Date: 7<sup>th</sup> October 2025  
Email: [REDACTED]@e-lindsey.gov.uk  
Our ref: B/25/0225  
Your ref: EN 010151

**Re: EN 010151 - Beacon Fen Energy Park – Section 90 Planning Act 2008.**

**Boston Borough Councils - Written Representation – Deadline One Submission - 7<sup>TH</sup> October 2025.**

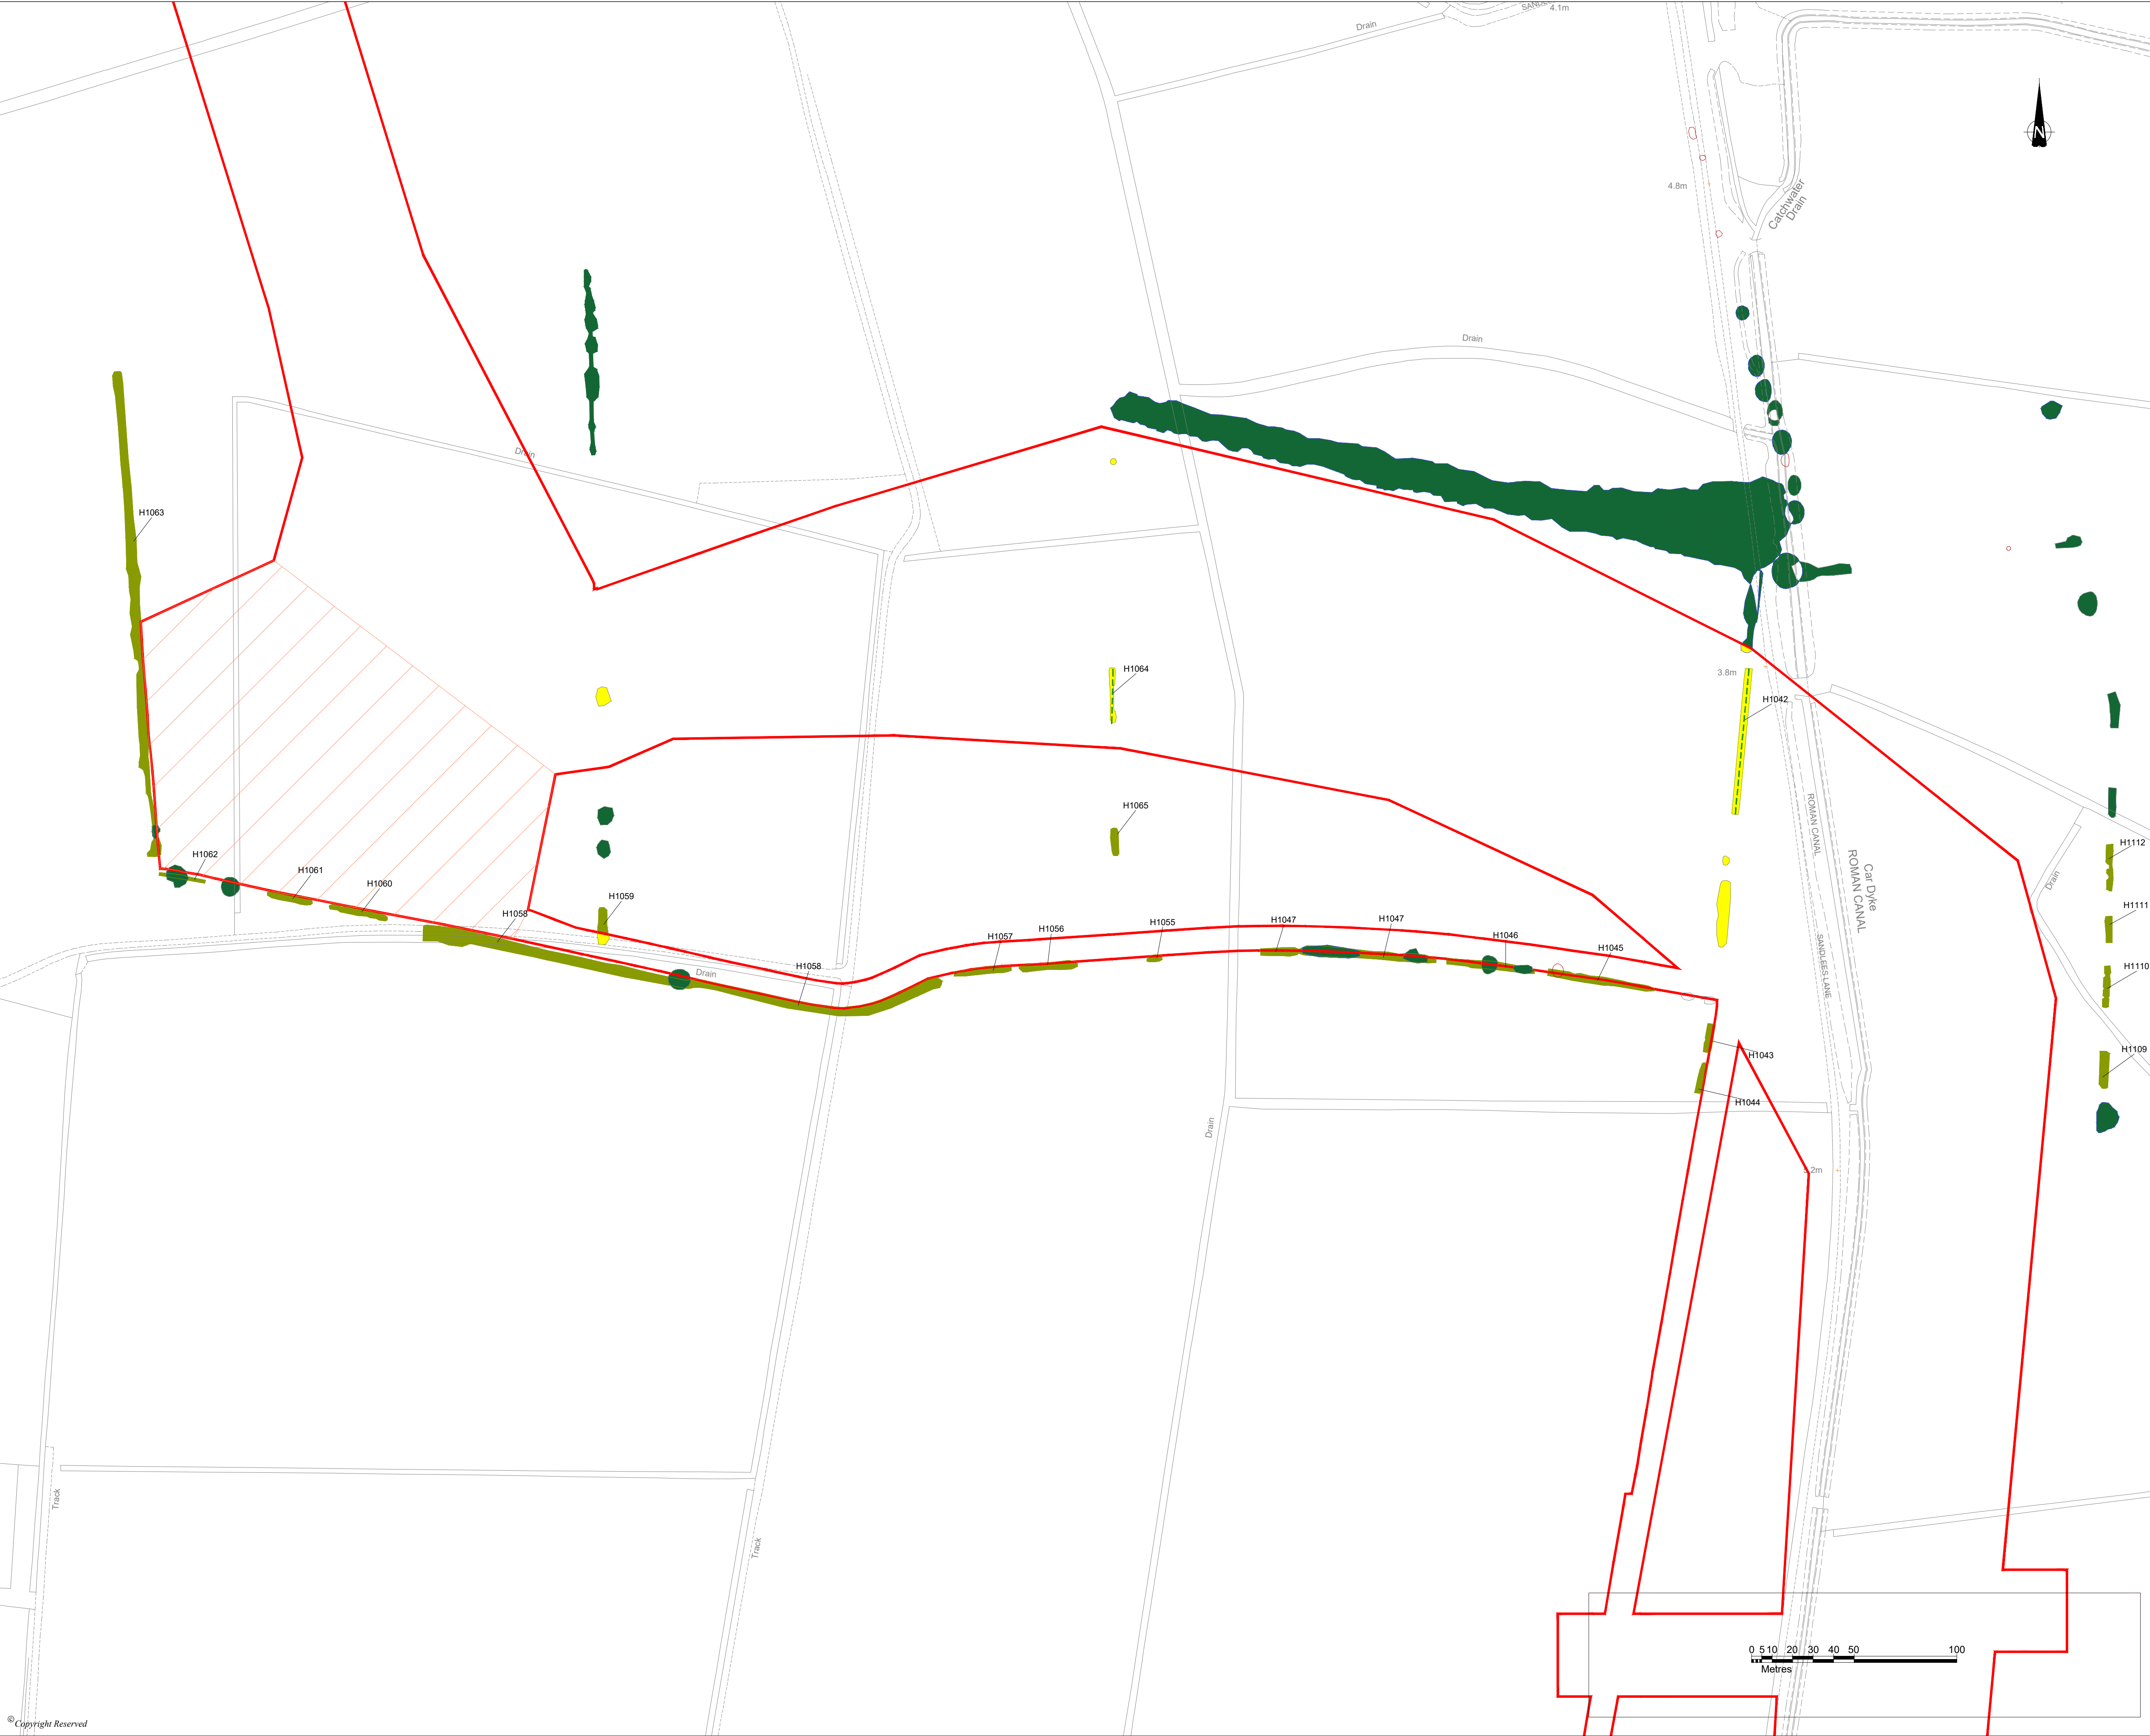
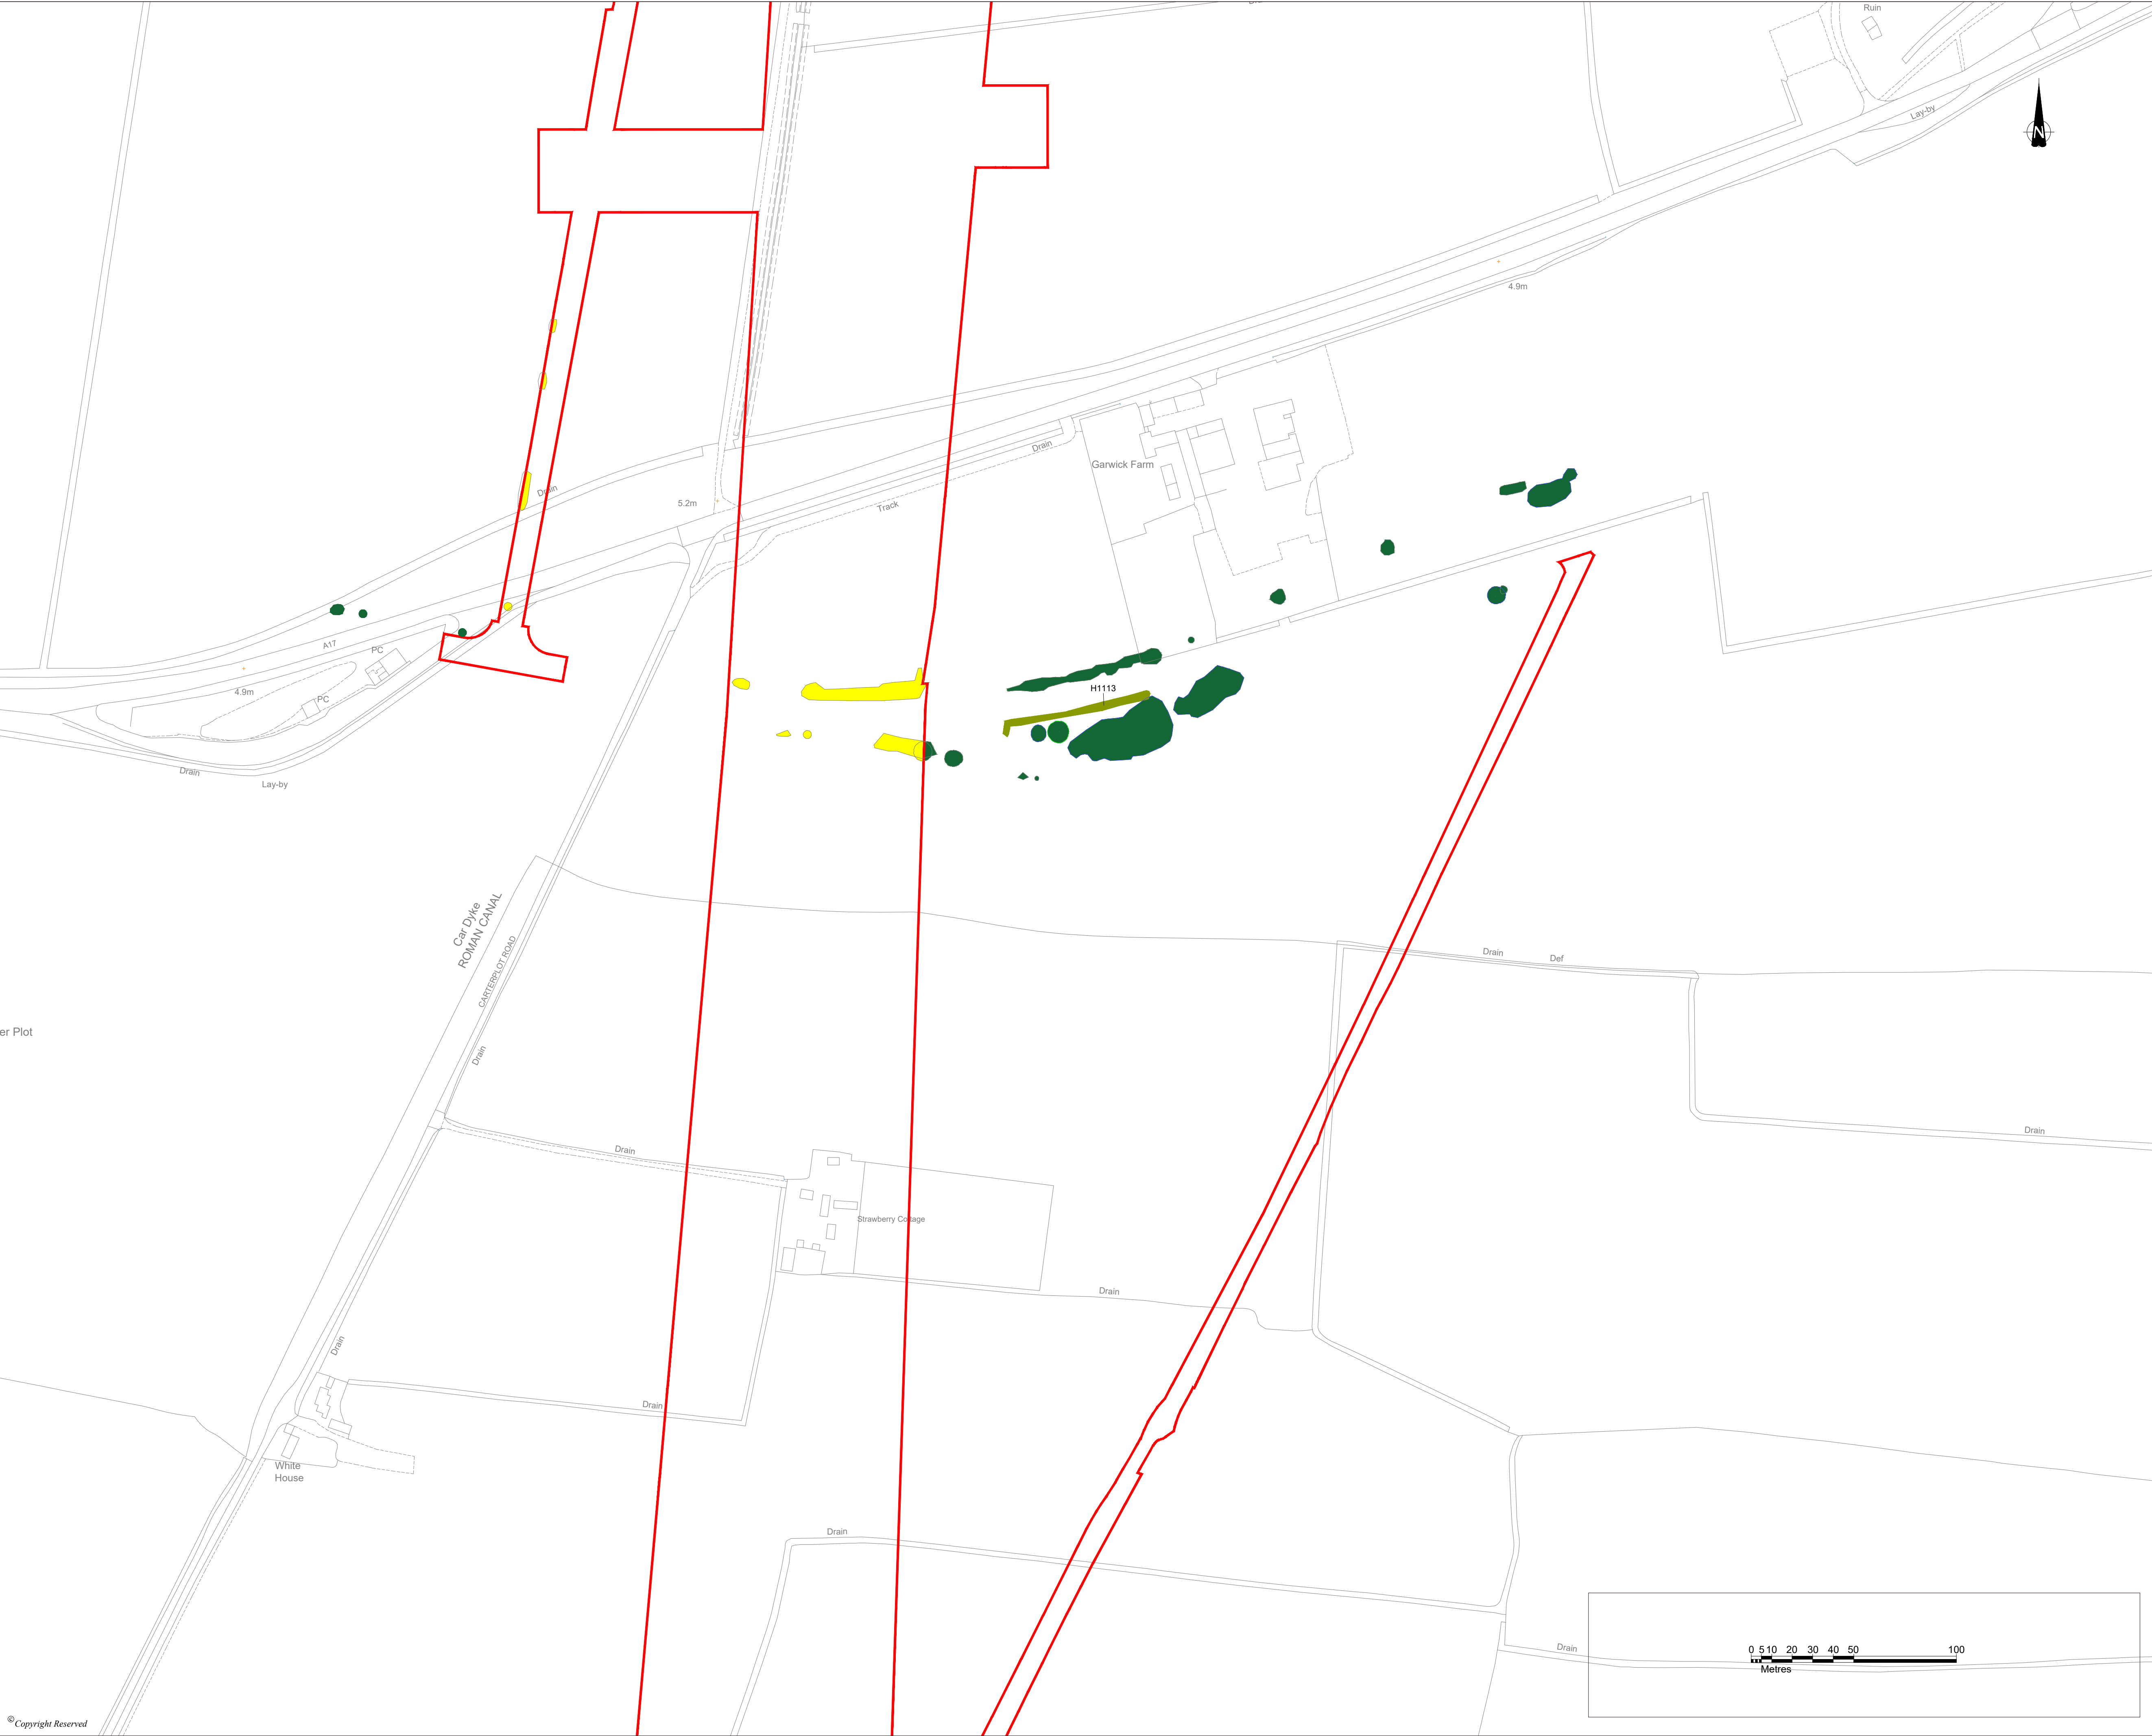
Vegetation Removal Plan 6.4.43c Fig 6.32 (APP-237) appears to show the potential removal of all vegetation within the LWS South Forty Foot Drain. The Borough do not understand why this is necessary, when the Applicant has committed too HDD crossing method (paragraph 2.8.3 of the Outline CEMP (APP-077)). The Applicant should provide Clarification on the Vegetation Removal Plans for South Forty Foot Drain and the commitment to use HDD trenchless crossing method at this location and how it is secured within the draft DCO .
